COLORADO GEOLOGICAL SURVEY

January 2, 2019

Subject: Forest Lakes Phase II PUD Amendment/Preliminary Plan – Additional Review
El Paso County, CO File No. PUDSP181; CGS Unique No. EP-18-0046

DESIGNED BY	MAL	SCALE	DATE	10/24/18
DRAWN BY	BB	(H) 1" = 60'	SHEET	10 OF 15
CHECKED BY		(V) 1" = N/A	JOB NO.	1175.21

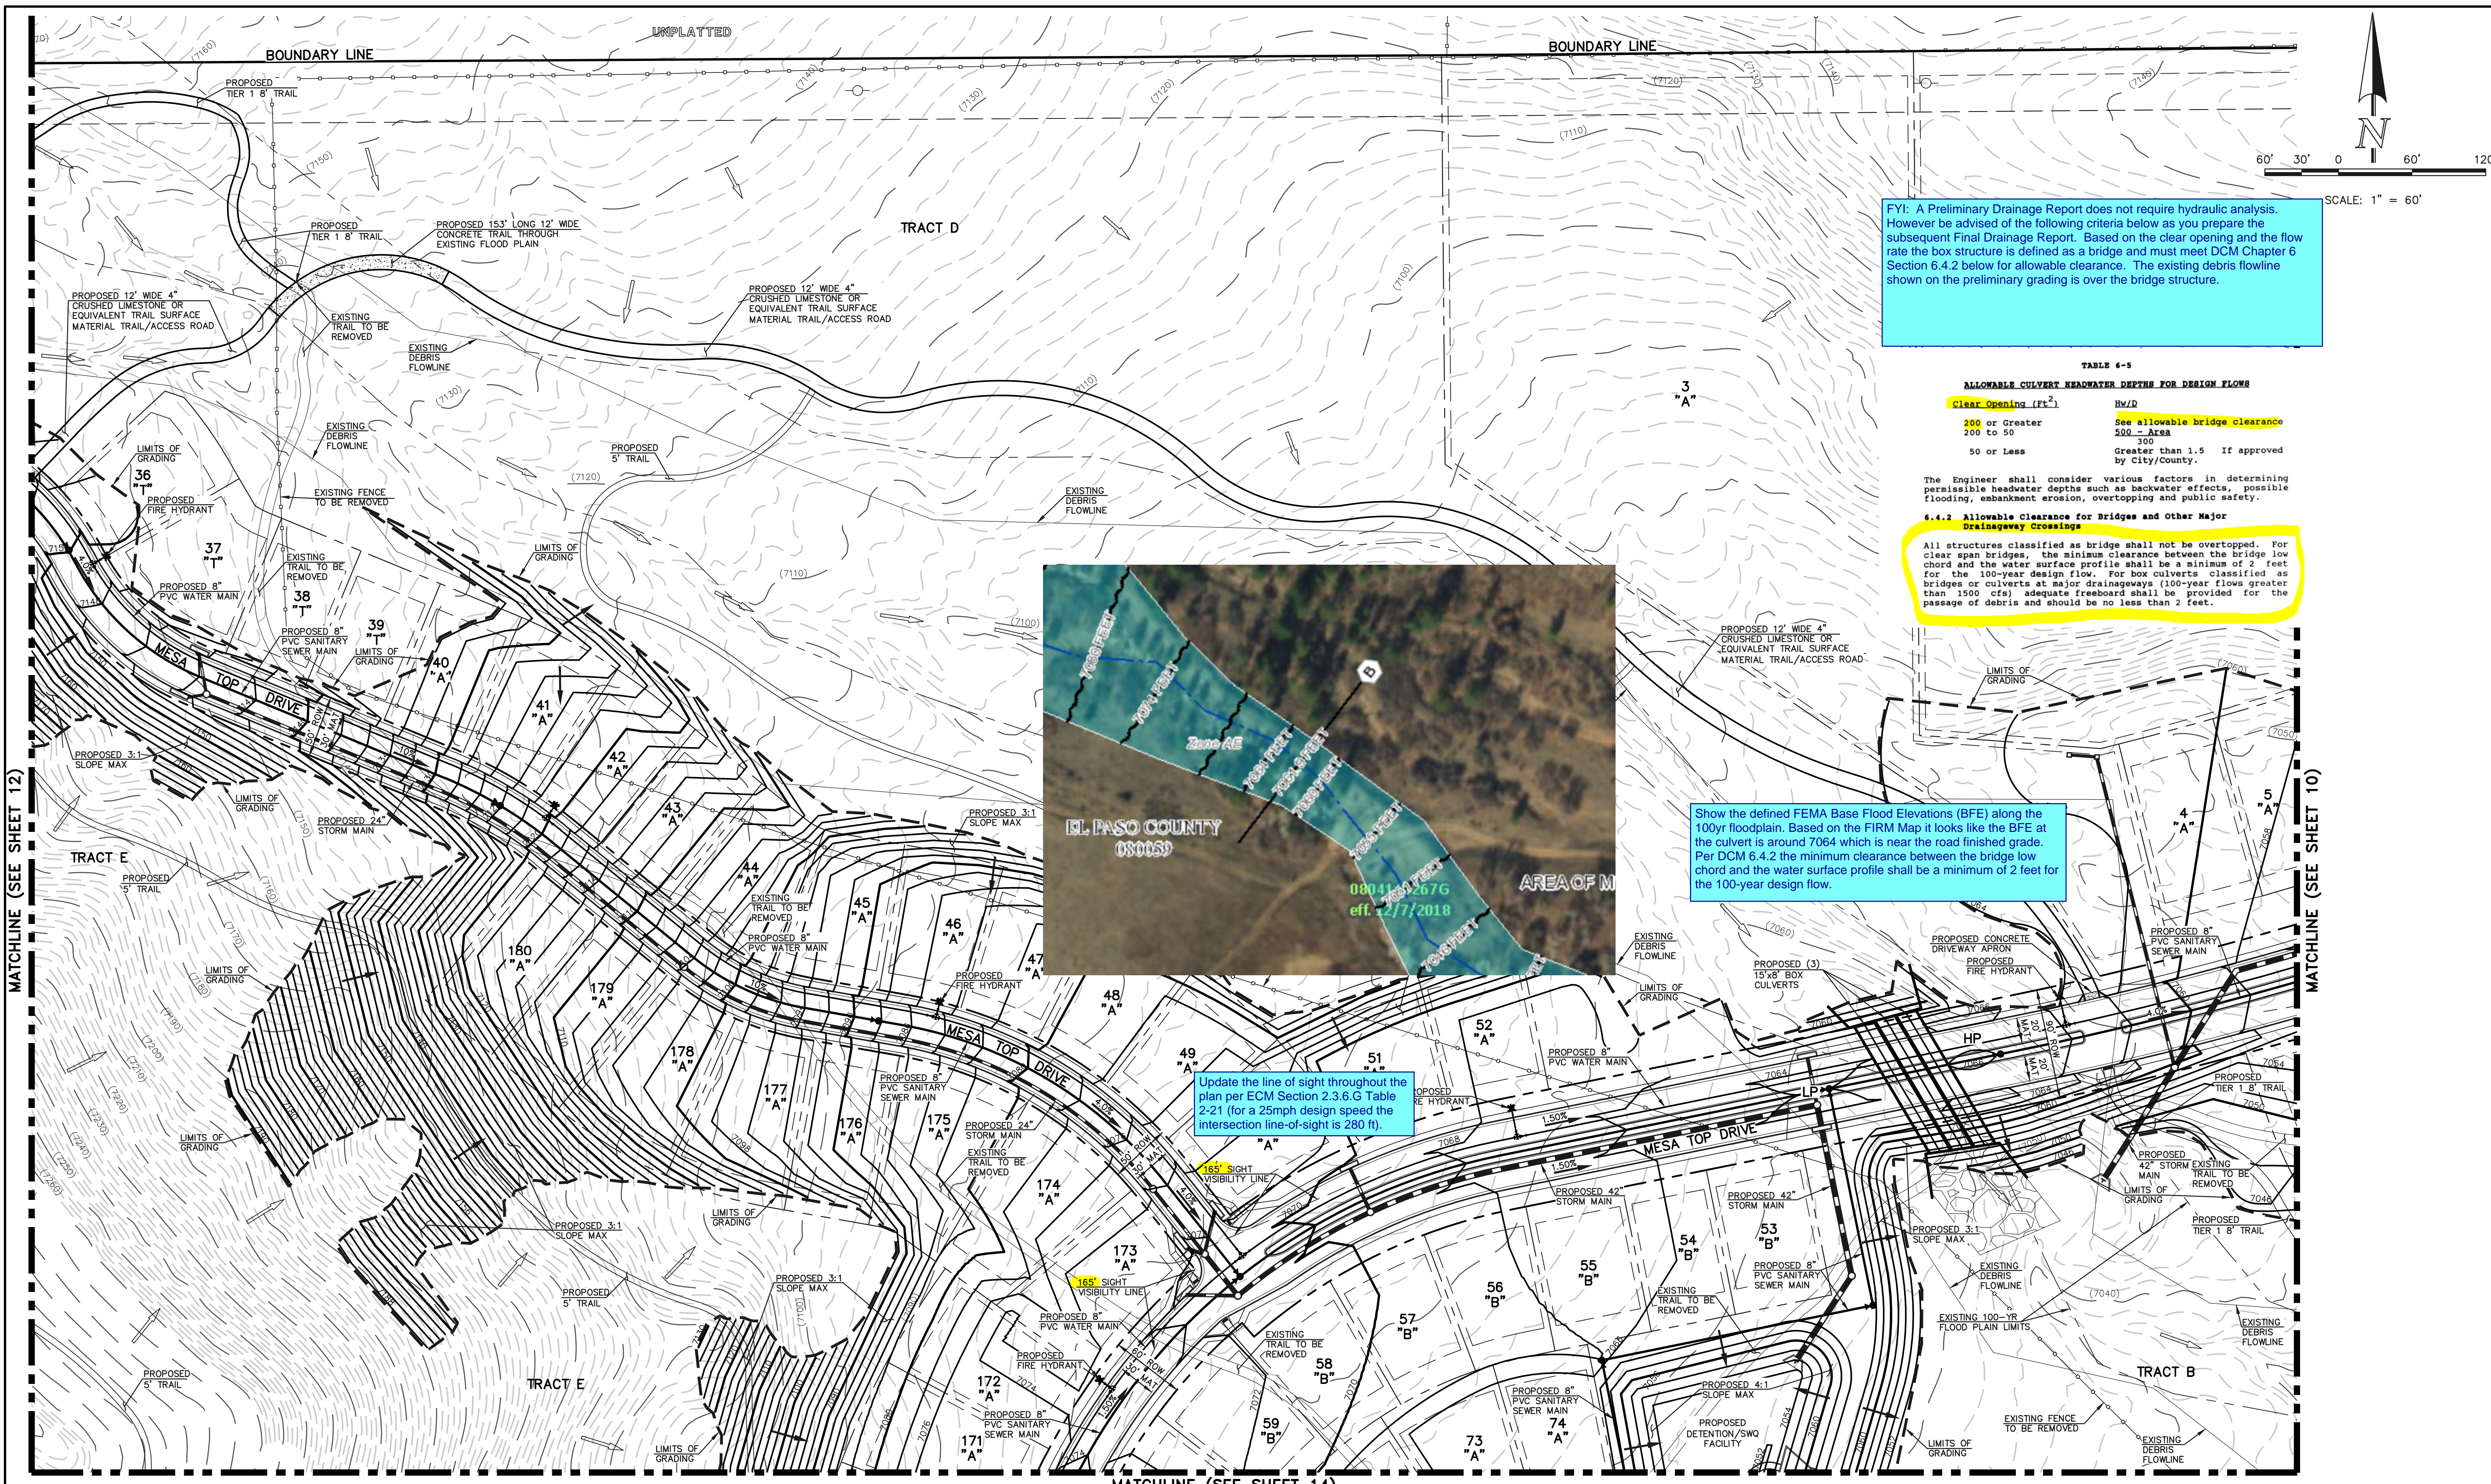
In the debris flow/mudflow analysis (page 9), CTL/Thompson expressed concern that the then-proposed culvert at the road crossing over North Beaver Creek may not be capable of passing the estimated 100-year flood event as used in their analysis. **The applicant's engineering consultant should confirm that the most up-to-date culvert design has been prepared to pass the most up-to-date 100-year flood discharge.**
